HANNAH RIDGE AT FEATHERGRASS FILING NO. 5

CONSTRUCTION PLANS

OCTOBER 2018

**CLASSIC**  
ENGINEERS & SURVEYORS

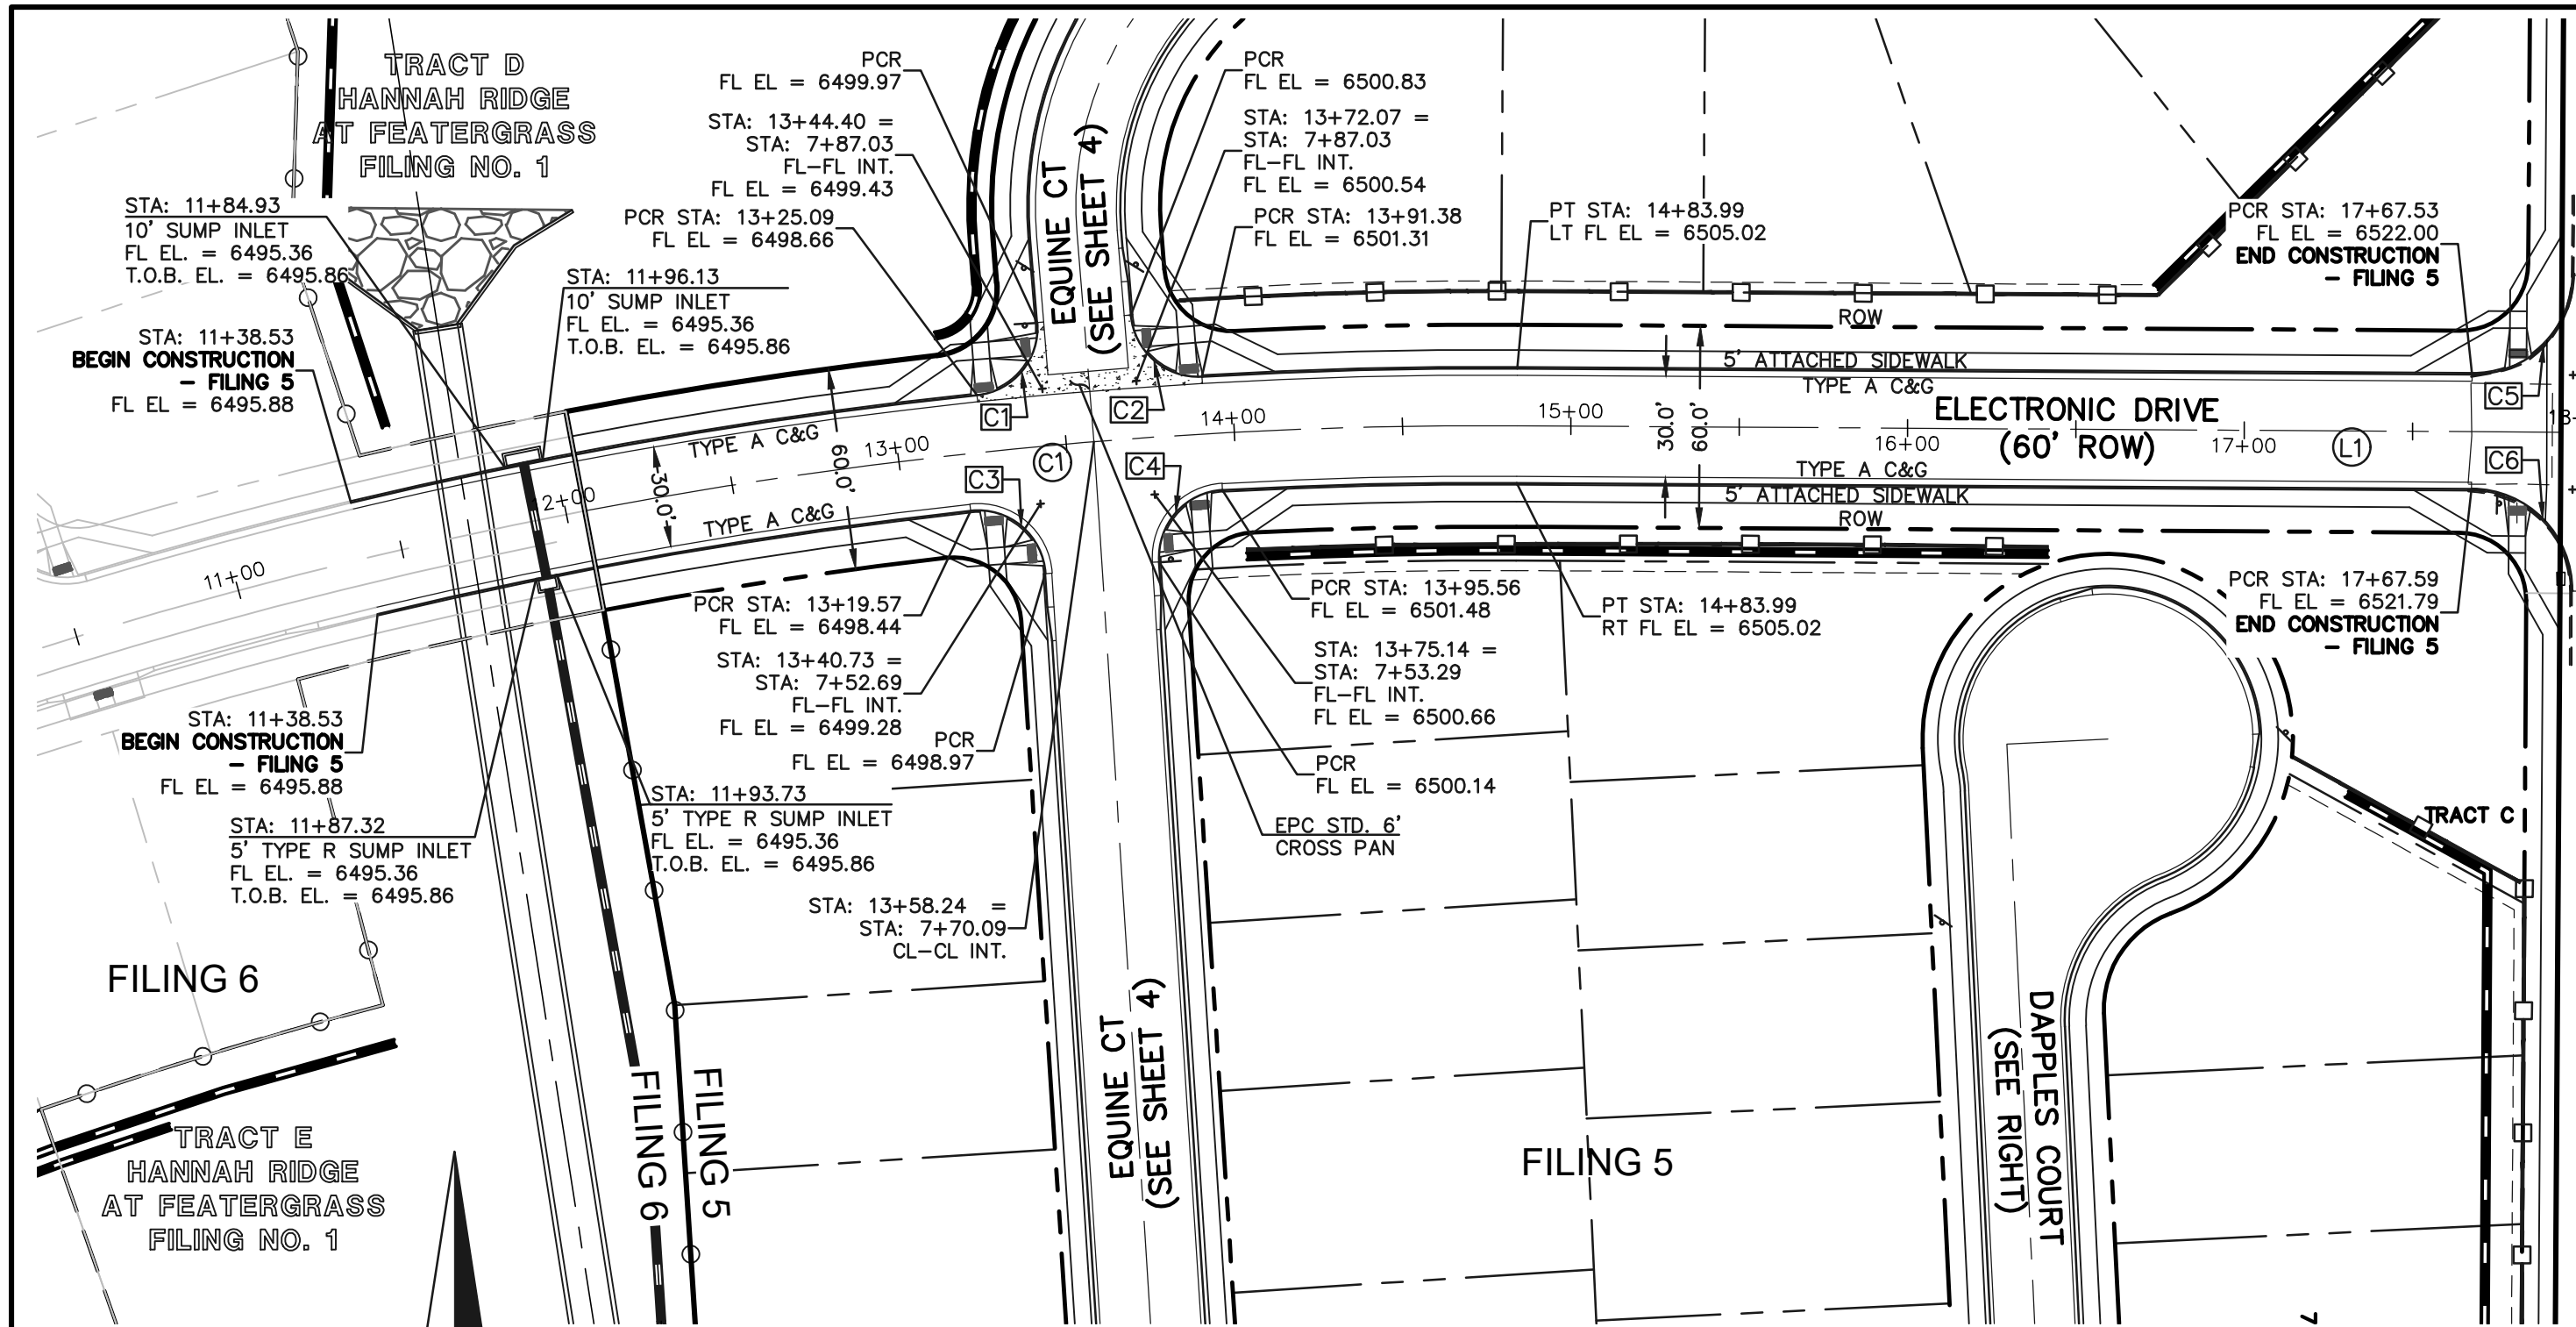
Provide Signing and Striping Plans for all three filings.
